# CITY OF ALBUQUERQUE

July 10, 2024

**Re: Stripes Burrito CO.  
2781 57<sup>TH</sup> St. NW  
30-Day Temporary Certificate of Occupancy  
Transportation Development Final Inspection  
Architect's Stamp dated 05-31-22 (H11-D073)  
Certification dated 07-02-24**

TRAFFIC CIRCULATION LAYOUT APPROVED
06/16/2022

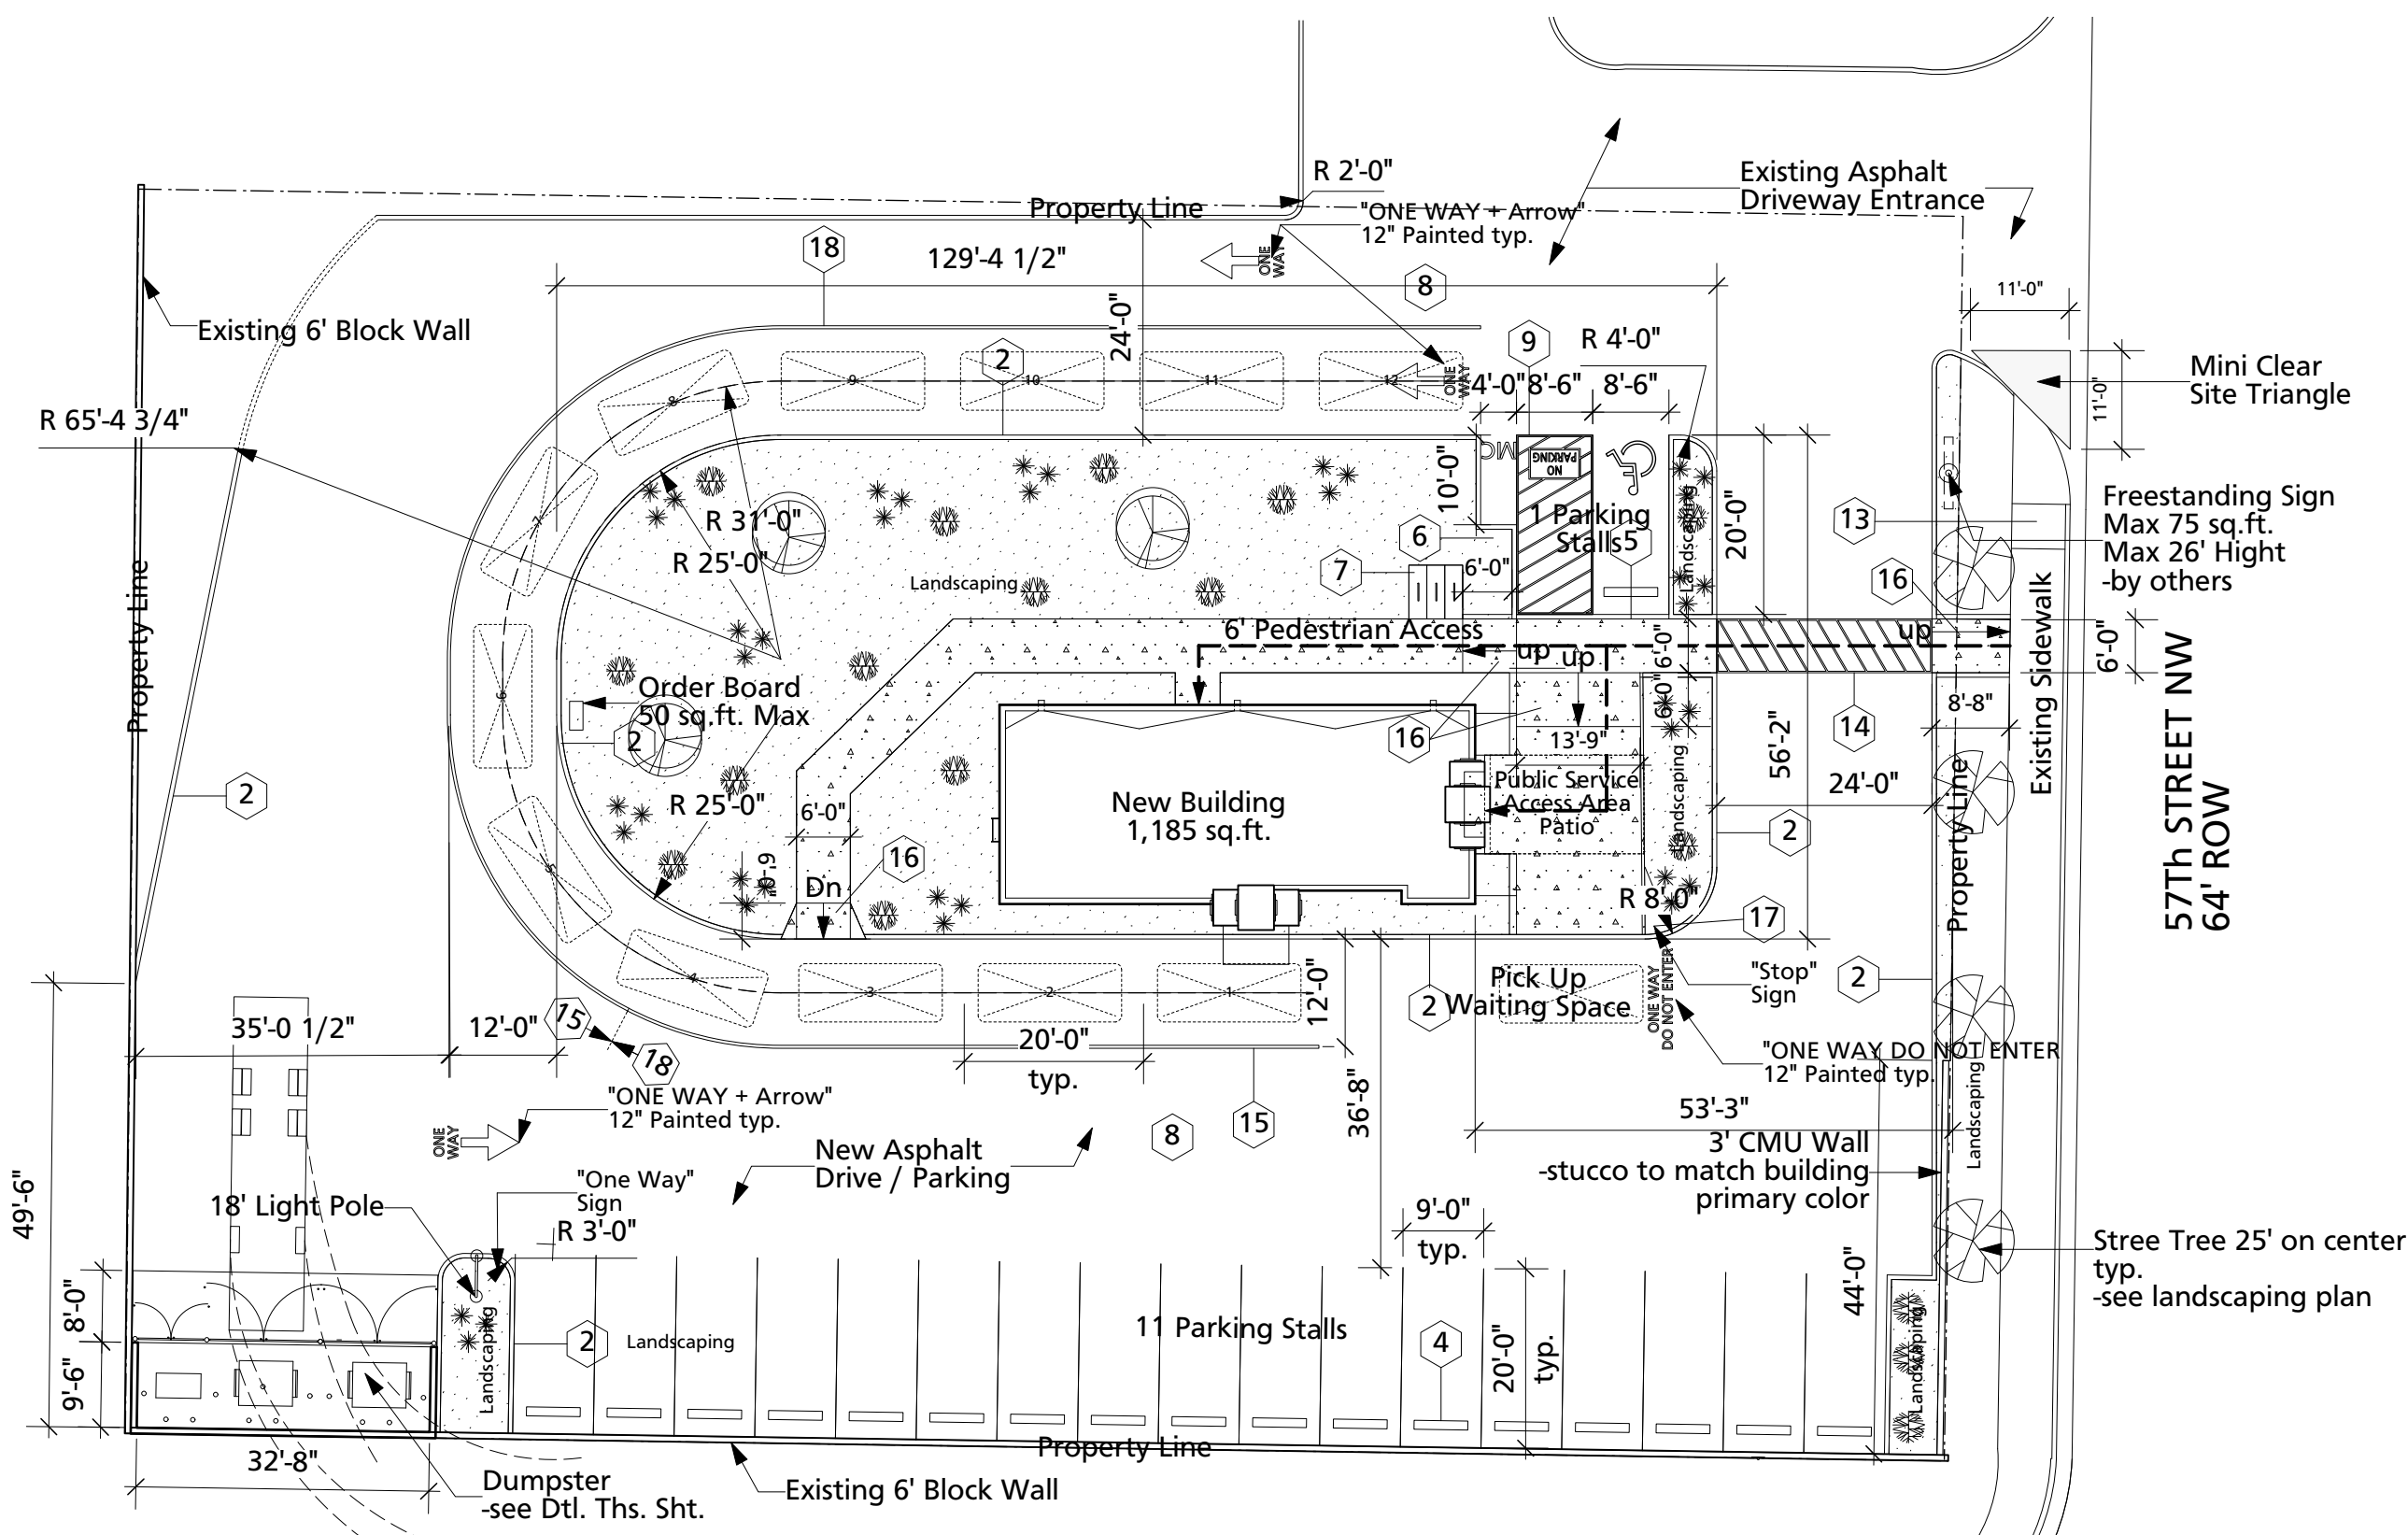
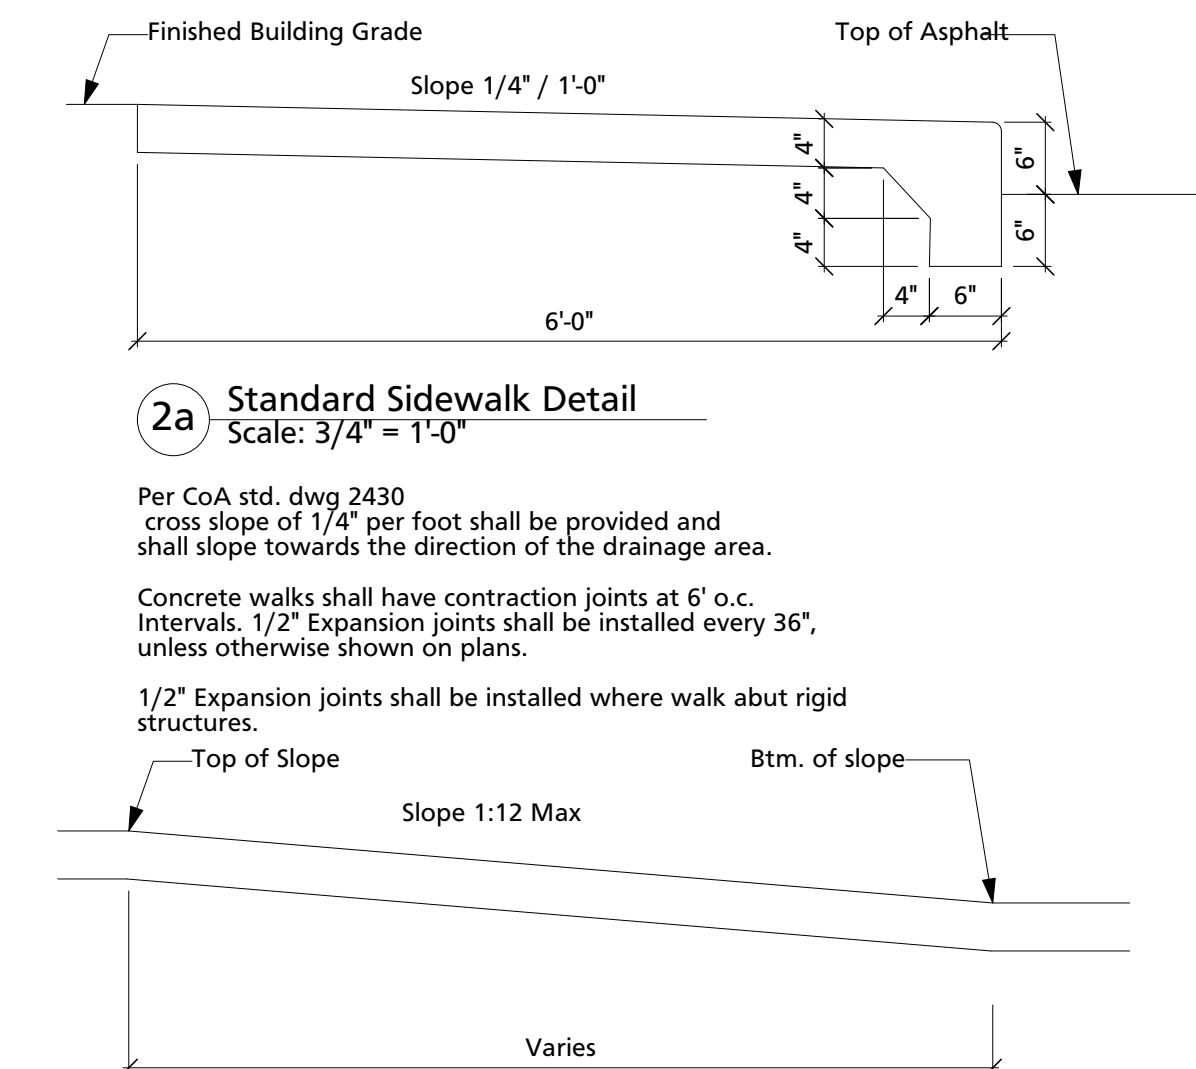
- Per approved site plan, please provide the "ONE WAY" pavement marking at the beginning of the drive-thru and the "DO NOT ENTER" pavement marking at the exit of the drive-thru lane.

HC / Motorcycle / One Way Sign Detail
Scale: 3/4" = 1'-0"

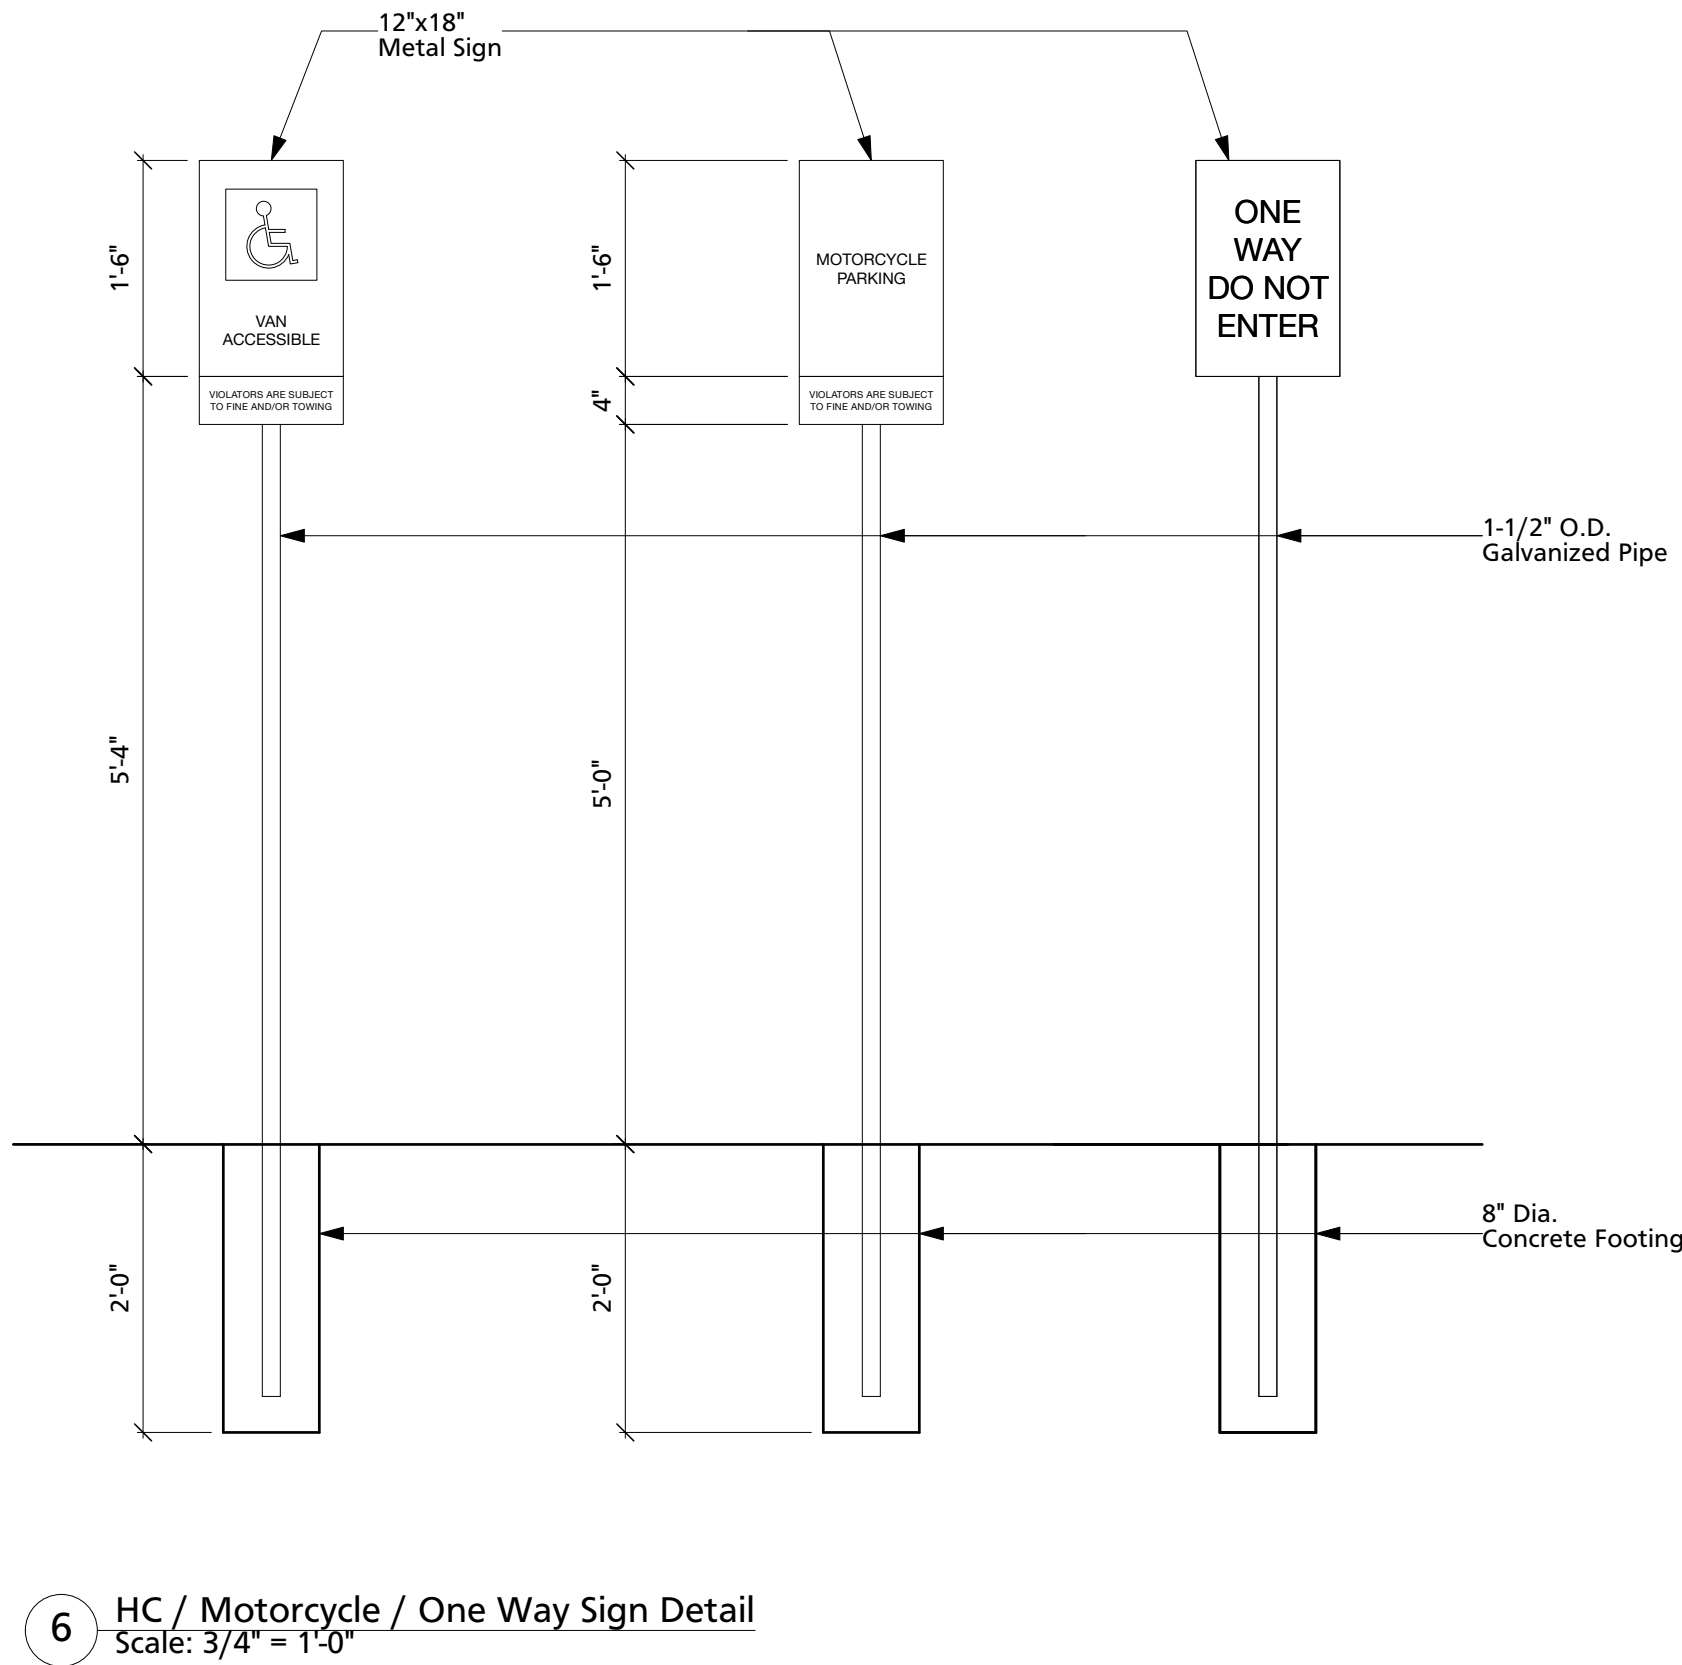
- The ADA accessible parking sign must have the required language per 66-7-352.4C NMSA 1978 **"Violators Are Subject to a Fine and/or Towing."** Please call out detail and location of signs.
- Per city requirements, ADA parking aisle must be striped with blue.

- Provide Motorcycle parking space sign.
